Phone: 0300 123 6780
Email: developeras@lancashire.gov.uk
Your ref: 3/2026/0207
Our ref: 3/2026/0207/HDC/KW
Date: 09 April 2026

Location: 29-33 Berry Lane Longridge PR3 3JA
Proposal: Proposed change of use from taxi office (Sui Generis) to children's role play centre (Use Class E(d)) including ancillary cafe (Use Class E(b)).
Grid Ref: 363351 437286

EXISTING AND PROPOSED PLANS
 LITTLE LONGRIDGE ROLE PLAY TOWN, UNIT D, 29-33 BERRY LANE, LONGRIDGE, PR3 3JA

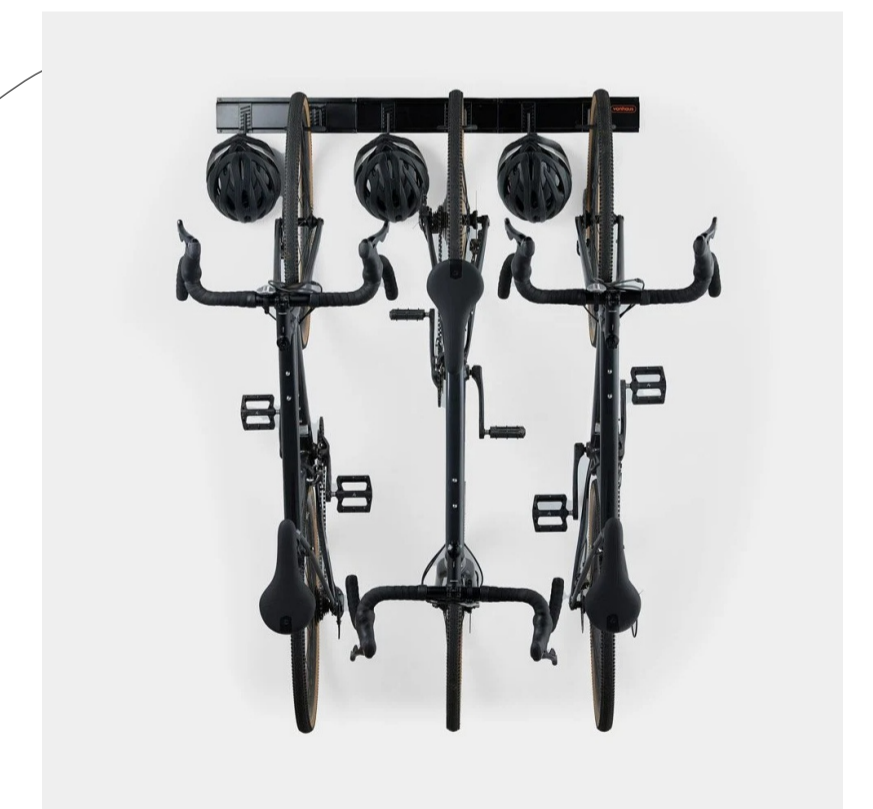
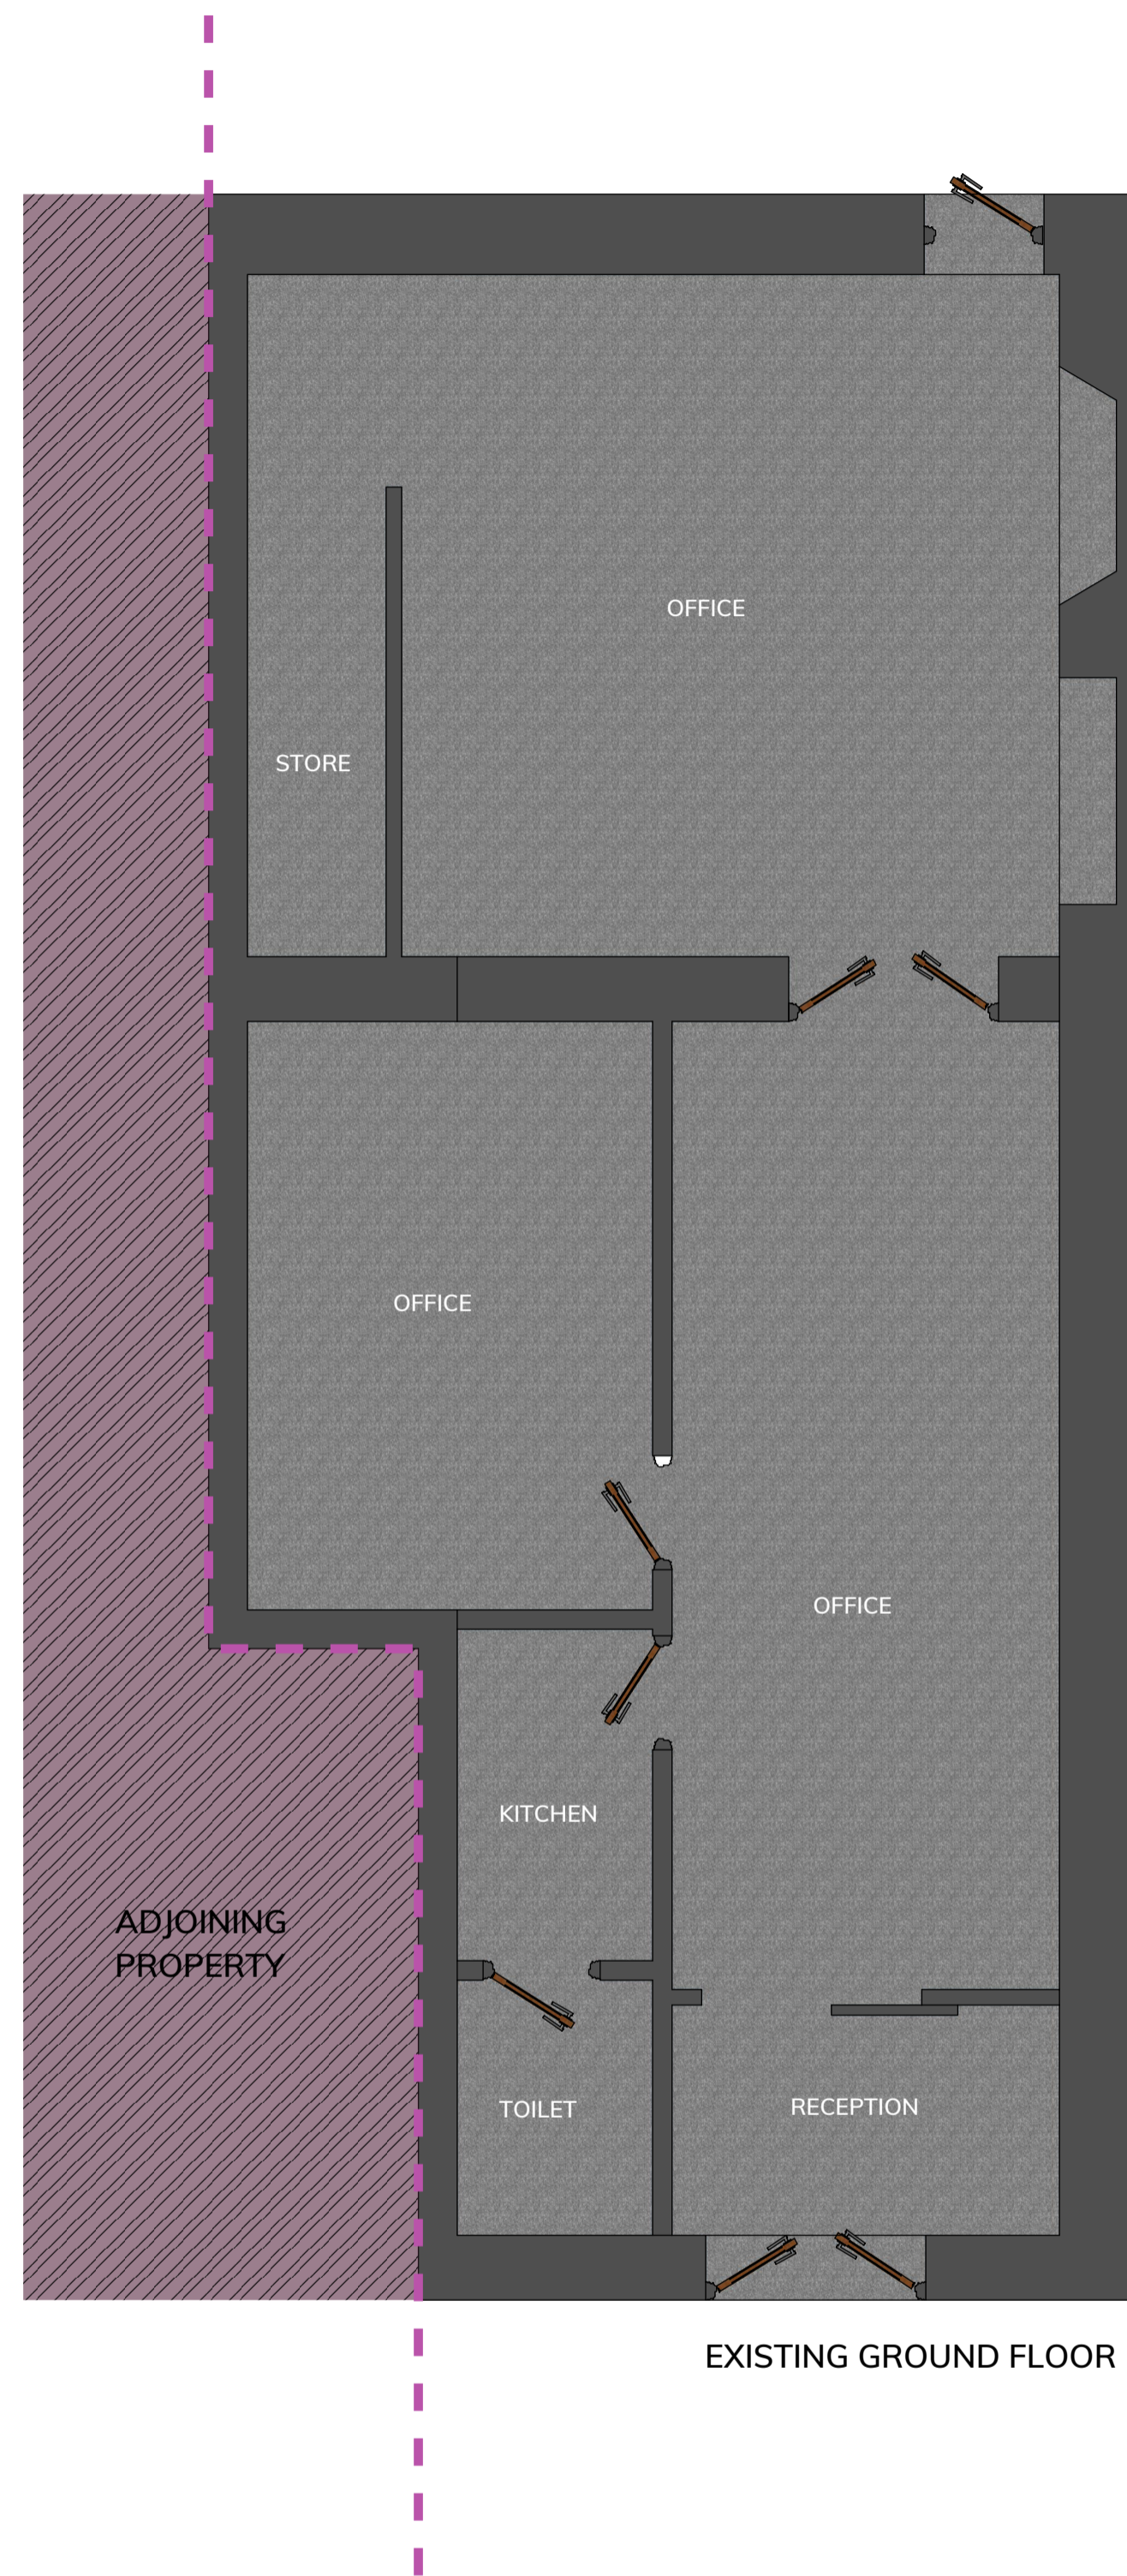
The site would also benefit from the introduction of covered secure cycle storage within the development to ensure the provision and availability of adequate cycle parking and the promotion of sustainable forms of transport, which can be utilised by employees.

1. Prior to the first use, cycle storage provisions for the commercial unit shall be submitted to the Local Planning Authority, in consultation with the Local Highway Authority. These cycle facilities shall thereafter be kept free of obstruction and available for the parking of bicycles only at all times.
